From: Simon Davis
Sent: 23 April 2019 10:32
To: Planning Scanning
Subject: FW: Conditions - Villa Maria BR/111/19/DOC

From: Simon Davis
Sent: 03 April 2019 17:20
To: Laura Gibbons [REDACTED]
Subject: FW: Conditions - Villa Maria BR/270/16/PL & BR/138/18/DOC

From: [REDACTED]
Sent: 25 March 2019 21:04
To: Simon Davis [REDACTED]
Subject: RE: Conditions - Villa Maria BR/270/16/PL & BR/138/18/DOC

I am trying to resolve these 2 outstanding conditions for the above site. These relate to the drainage and the tree works. Conditions 3 and 4 respectively.

PROPOSED DRAINAGE PLAN
(1:100)

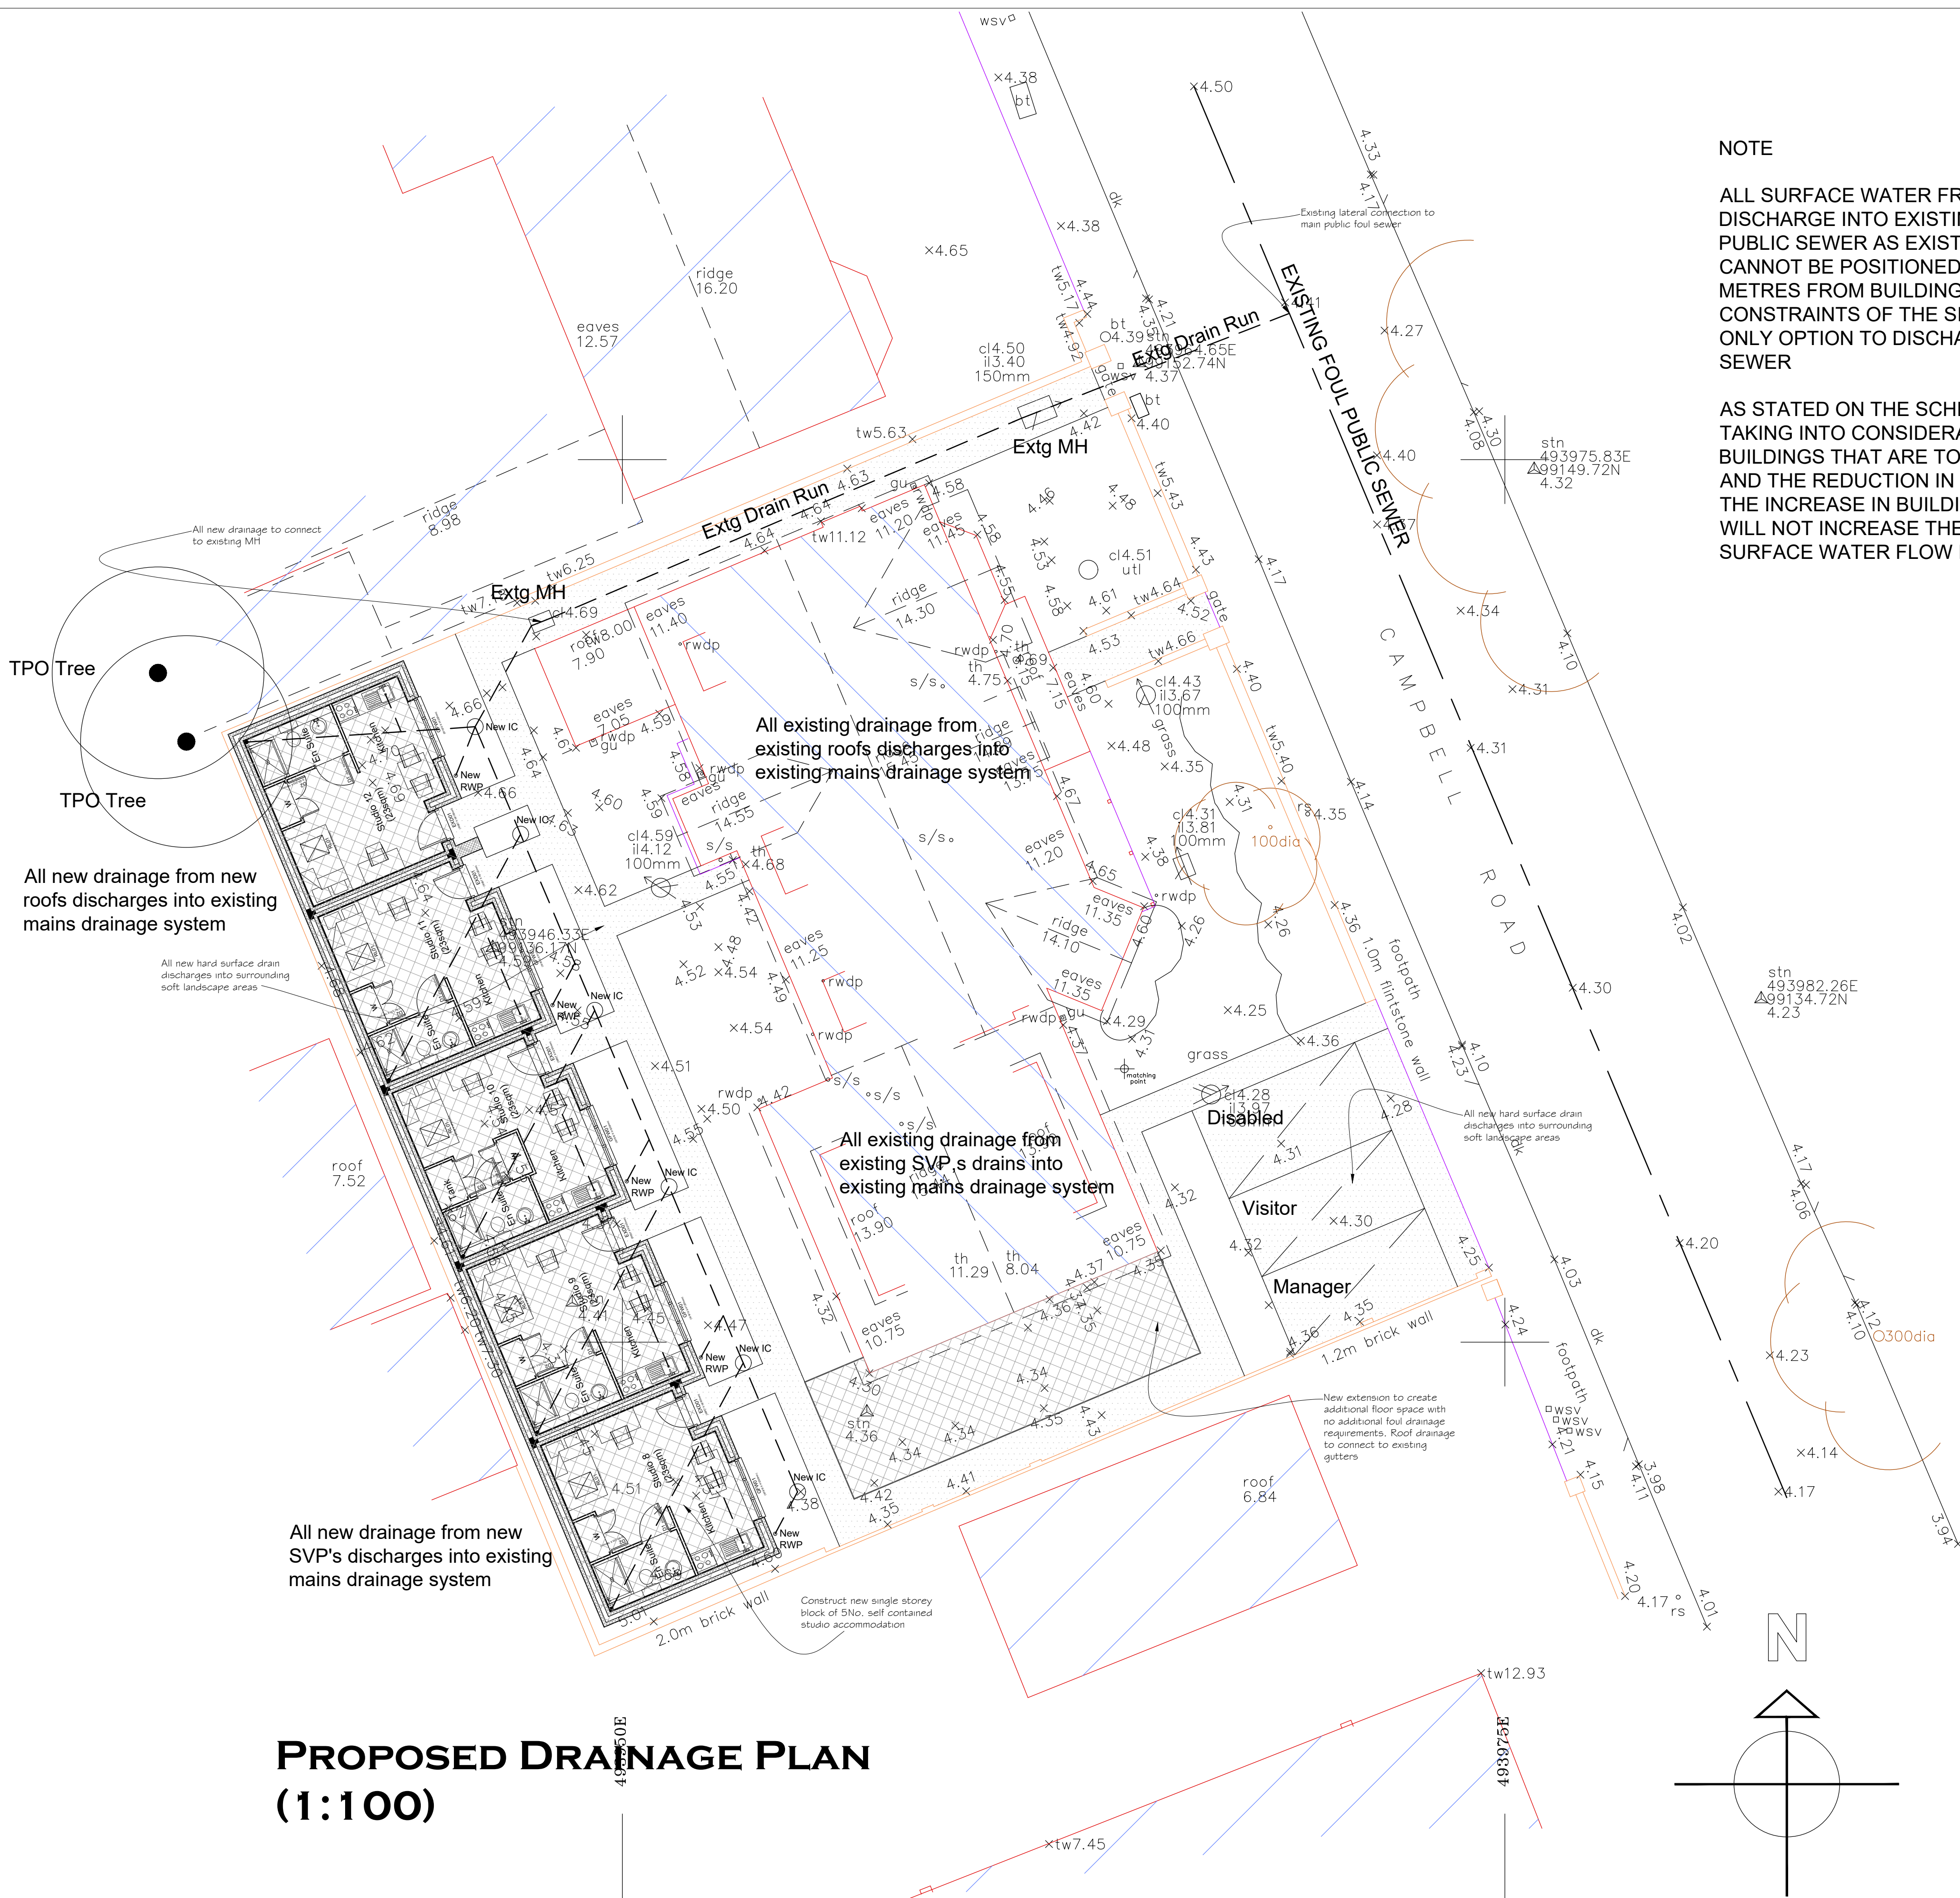
I understand that Laura wrote to you in early March to advise that she requires confirmation from Southern Water that a capacity check has been satisfactorily completed. She has said that she cannot sign-off on the proposals

until/unless she has seen this. I also note that Southern Water's approval letter does say that their approval for discharge into the public foul sewer does not confirm that capacity is available for the proposed development and that a lack of capacity may increase the risk of flooding and that this is a material planning consideration for the Local Planning Authority to consider. I am advised that the costs associated with the capacity check are not particularly high (I believe less than £500) so would your client not be prepared to undergo this process?

I appreciate that Laura wants a capacity check done however it is not the fact that my client doesn't want the cost. I do not see the point of a capacity check in relation to the proposed development. As part of the submission to Southern Water we provided full calculations from a drainage engineer which proved that there is no increase in the flow rate into the public sewer resulting from the proposed development. Therefore why ask for a capacity check? We have not made the situation any worse than the existing situation where all foul and surface water went into the public sewer!!! If we do a capacity check and Southern Water say there is no capacity for the existing flow rate then

that is not my clients problem and is not a result of the proposed development. Therefore it is not a material consideration in the planning process as the proposed development has not increase the flow rate to what was already going into the sewer before my client acquired the building.
